From: Sue Howell
Sent: 10 August 2017 15:24
To: Planning.Responses
Cc: David Innes
Subject: RE: Planning Consultation on BE/96/17/DOC

Comment from Greenspace

APPLICATION NO: BE/96/17/DOC

Works: conditions imposed on planning permission
BE/122/10 relating to conditions 4 (General
arrangement external works) & 6 (LEAP details)

Scheme No: 29613rev4/HAM Date: 30/11/16 Drawn by: NR/MB

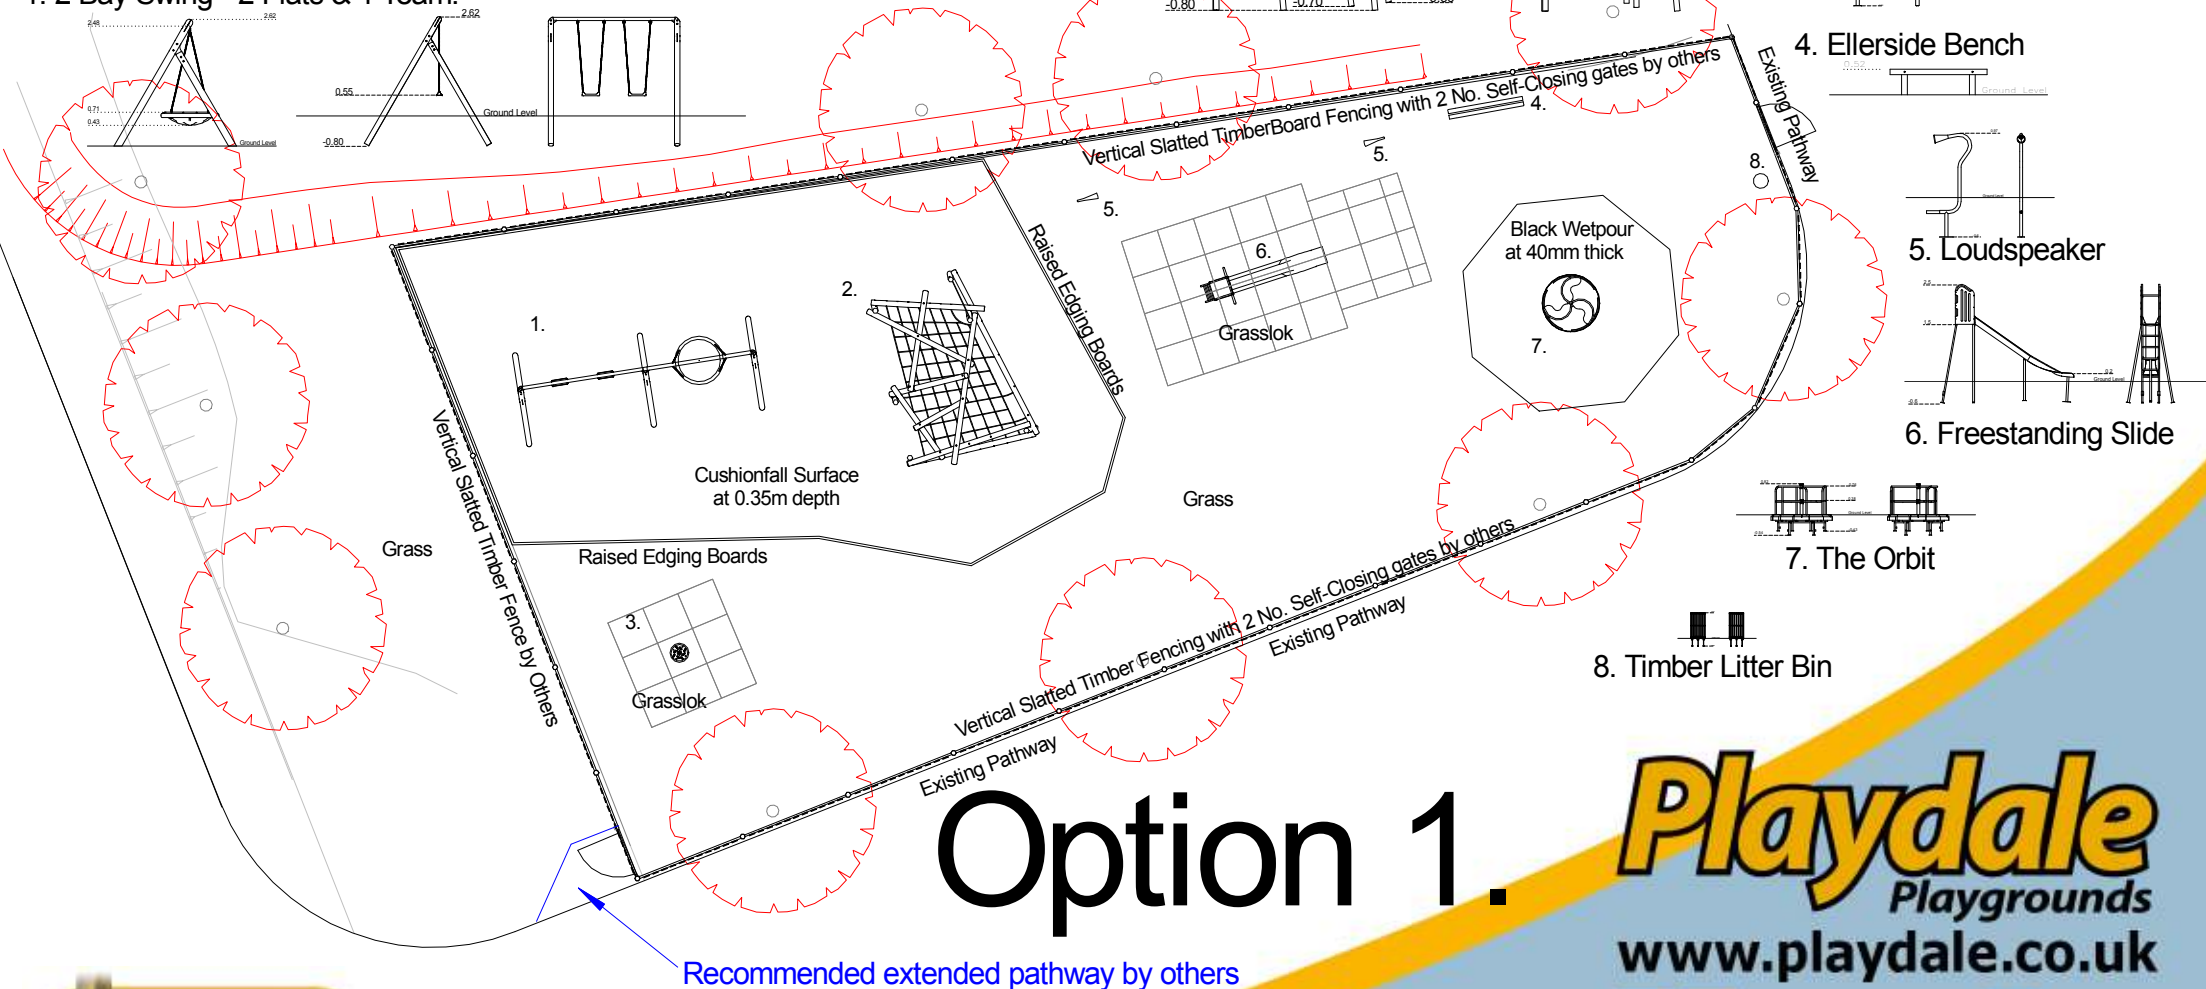
Further to submission of Option 1 Playdale Dwg Scheme no: 29613 rev 4/HAM 30/11/16 containing LEAP detail, we confirm that that the paly equipment proposed is suitable for location, giving a good range of play offer. We would however request that the fencing type is changed to metal bow top at appropriate height, rather than vertical slatted timber fence as shown. We would also require that the gates are connected to pathways for ease of access by users and wheeled users and that any gate bordering a road is inward rather than outward opening.

We would not recommend the discharge of Condition 6 on application BE/96/17/DOC imposed under application BE/122/10 until the fencing detail above is amended and submitted for approval.
